# MDT-SF23001-R1-Plat.pdf Markup Summary

# HILLSIDE AT LORSON RANCH FILING NO. 1

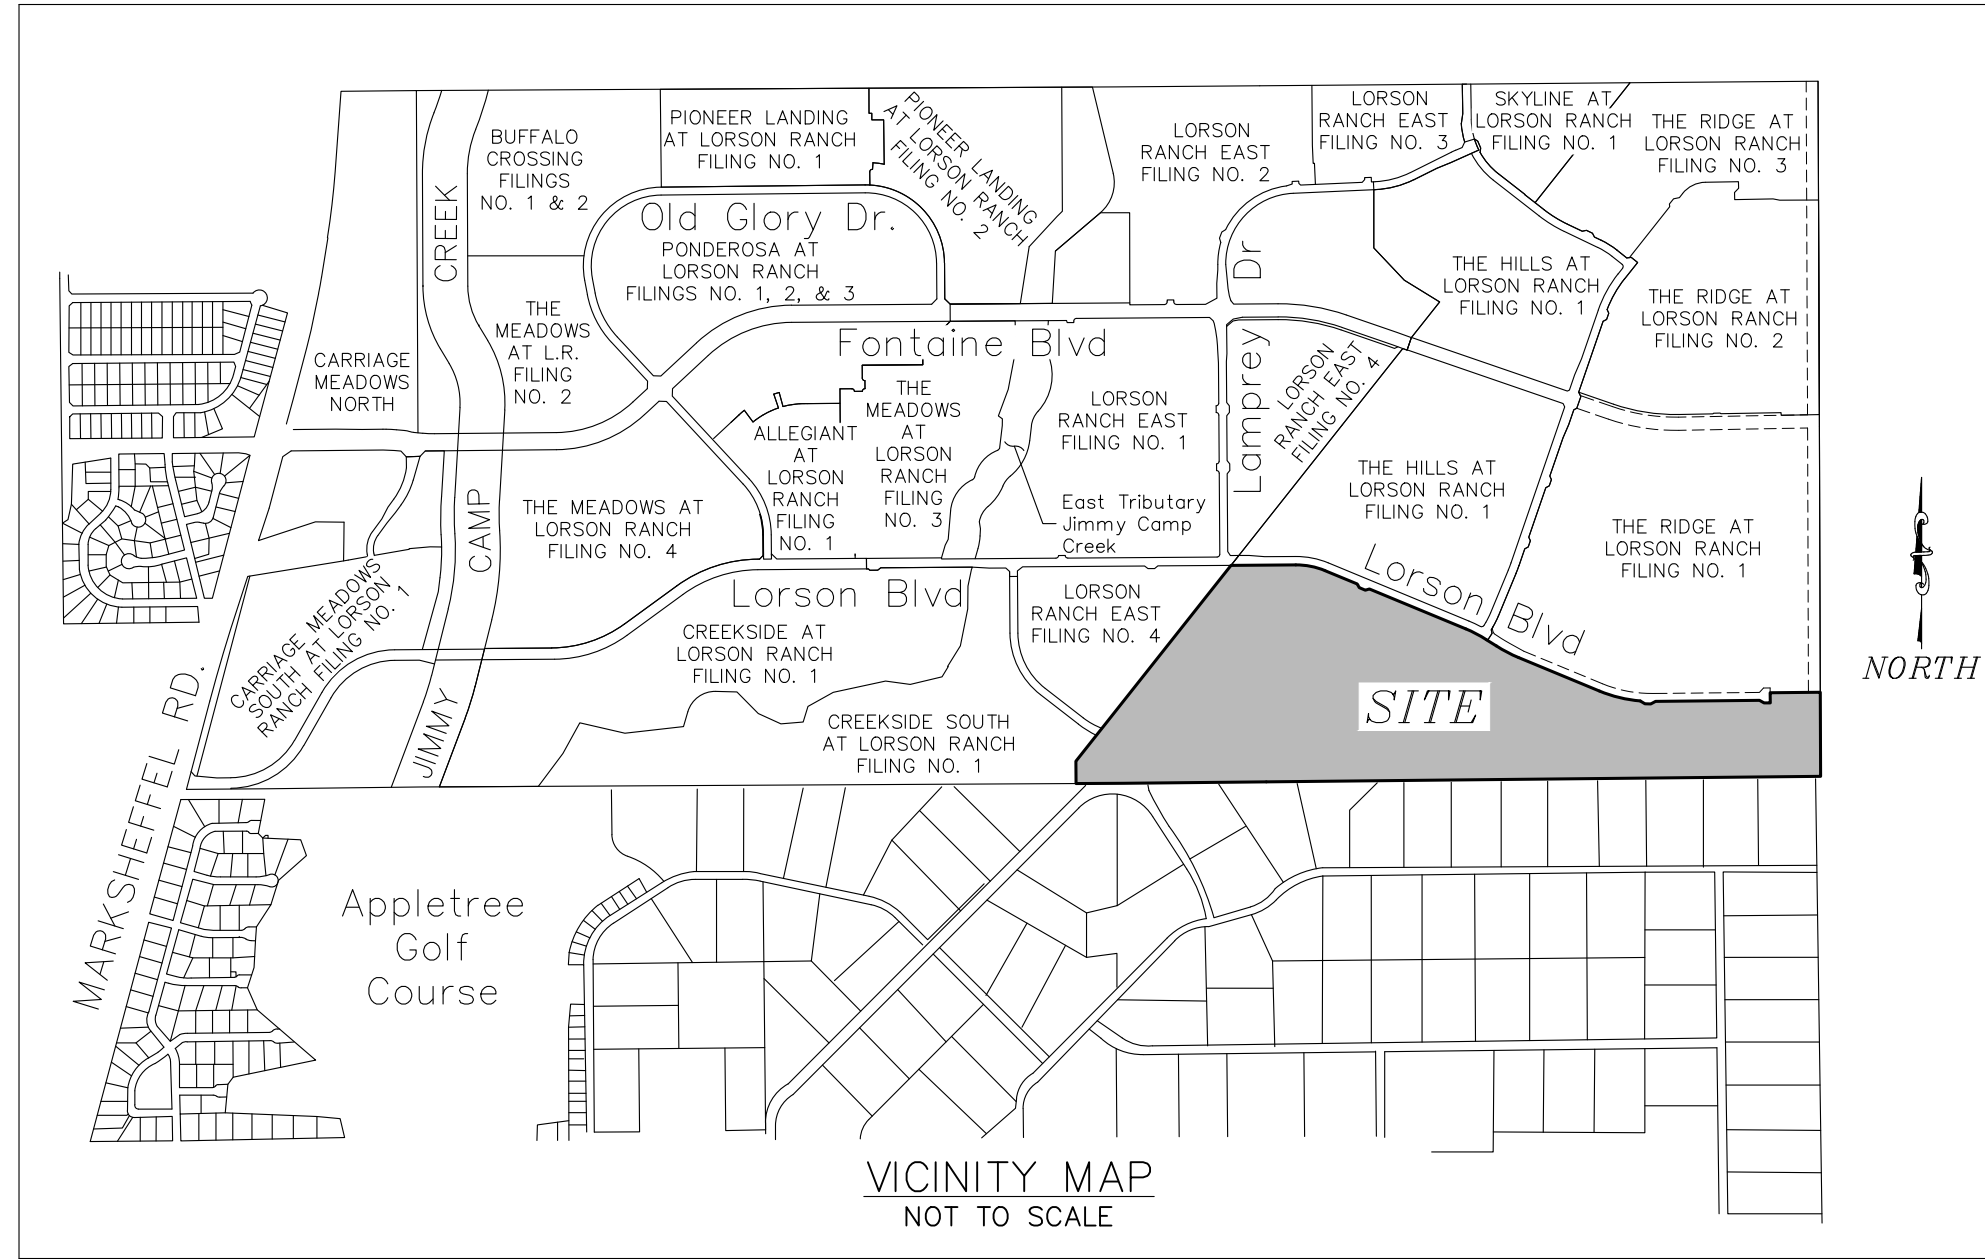
not needed if PPRBD stamps Mylar (this was a Covid work around)

please provide recorded Parkland Agreement

delete extra digit

Revise per any drainage report revisions

FINAL PLAT  
 HILLSIDE AT LORSON RANCH  
 FILING NO. 1  
 JOB NO. 43-141  
 DATE PREPARED: 09/20/2022  
 DATE REVISED: 12/20/2022

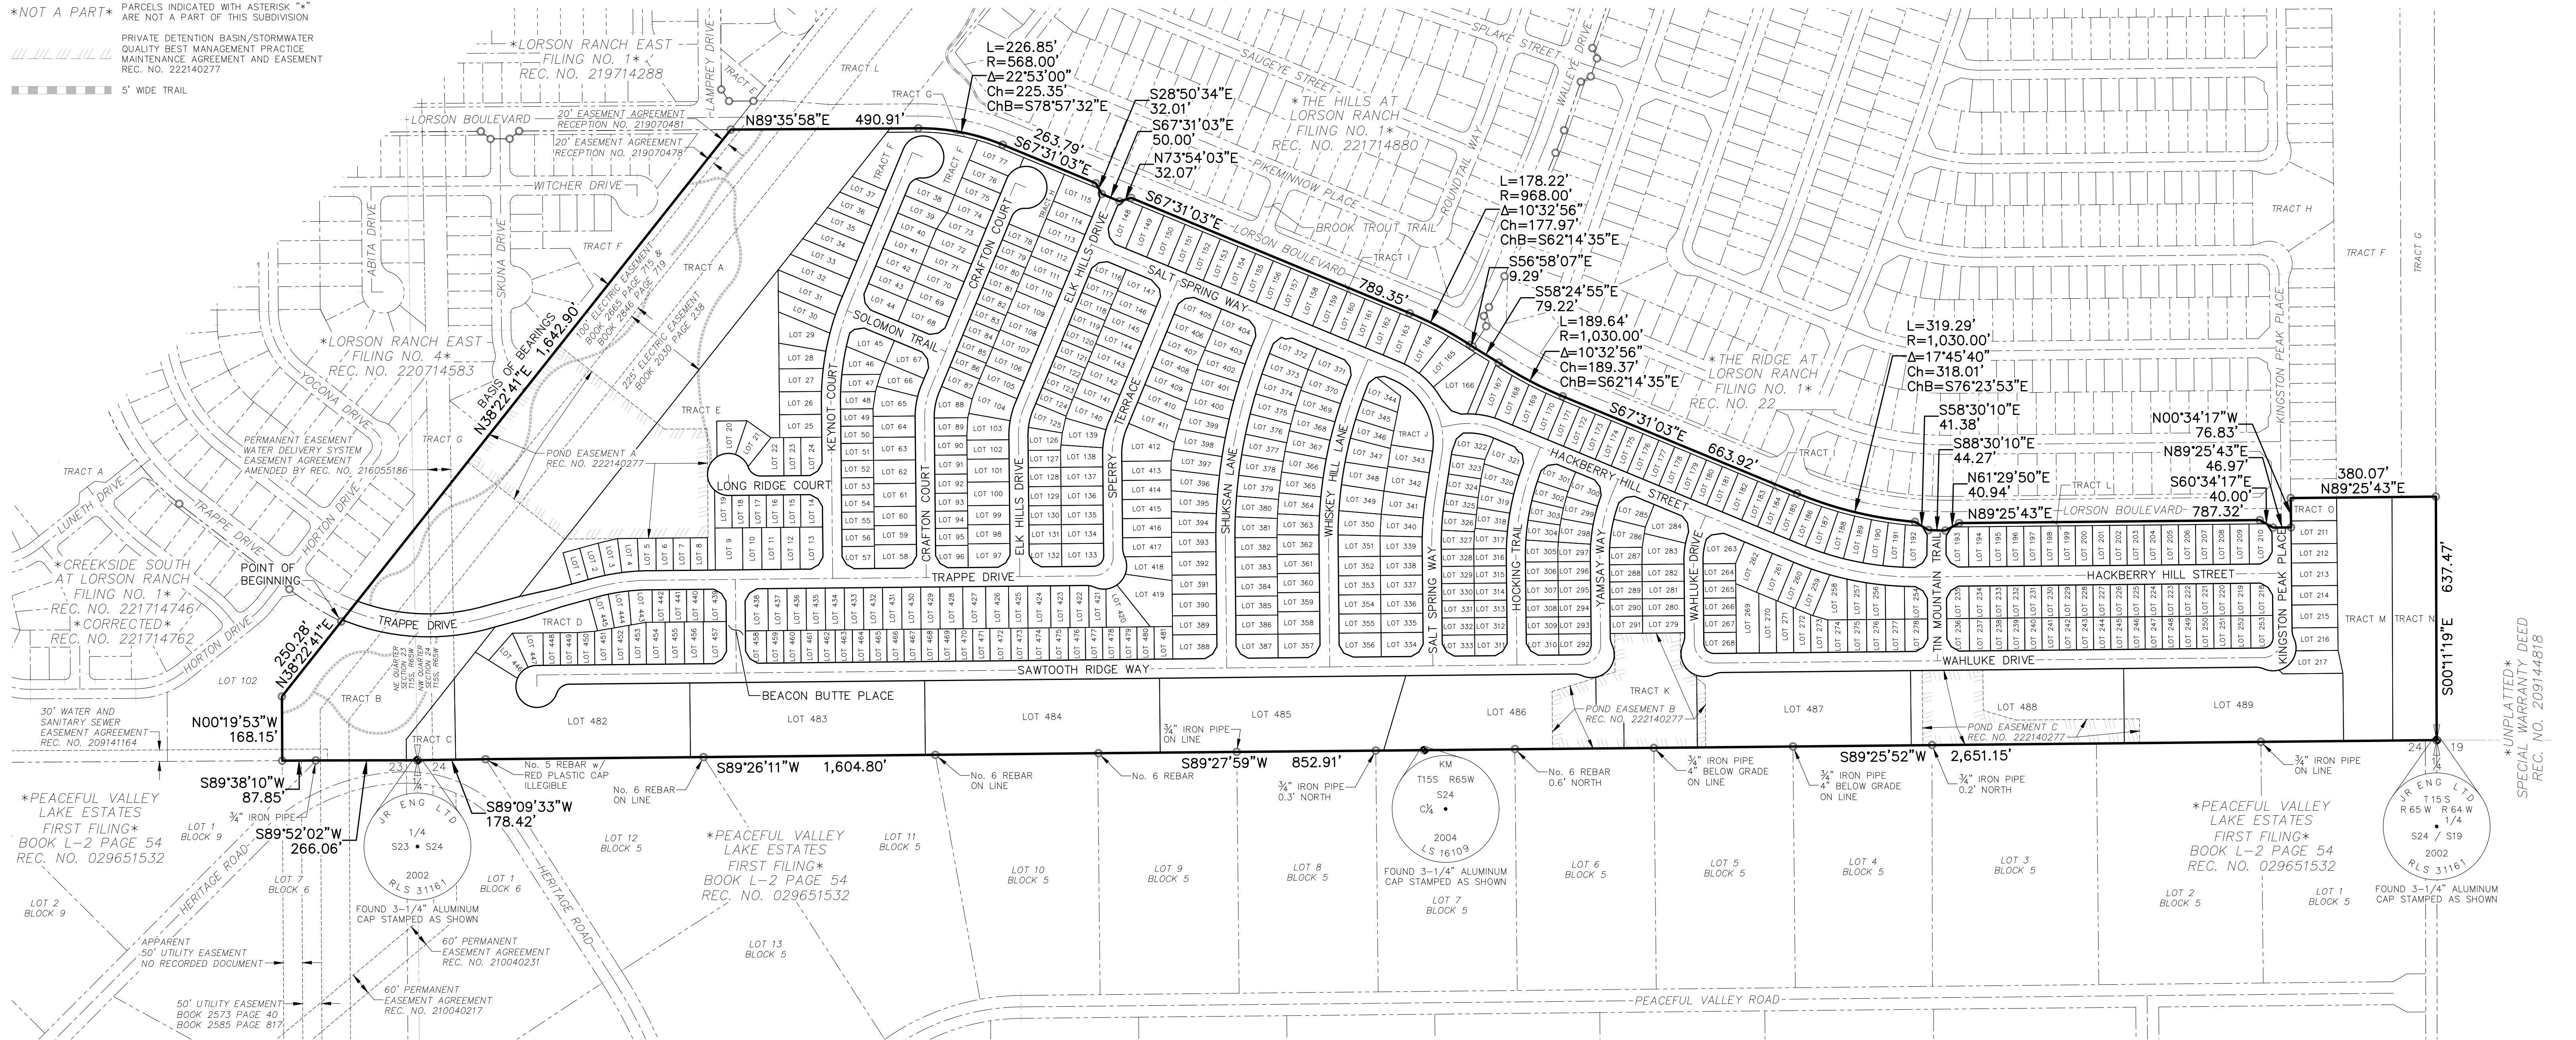
Include benchmark

complete this note

repeat not from page 1- not needed if PPRBD stamps mylar

reception number of Prk Agreement needs to be added

complete this note; the consultants job number is not necessary

UPDATE GEO note to match PUDSP

add a disclosure note

provide

Replace with:  
No driveway shall be established unless an access  
permit has been granted by El Paso County.

Add:  
There shall be no direct lot access to Lorson  
Boulevard.

and amended as recorded at reception no.  
216113013
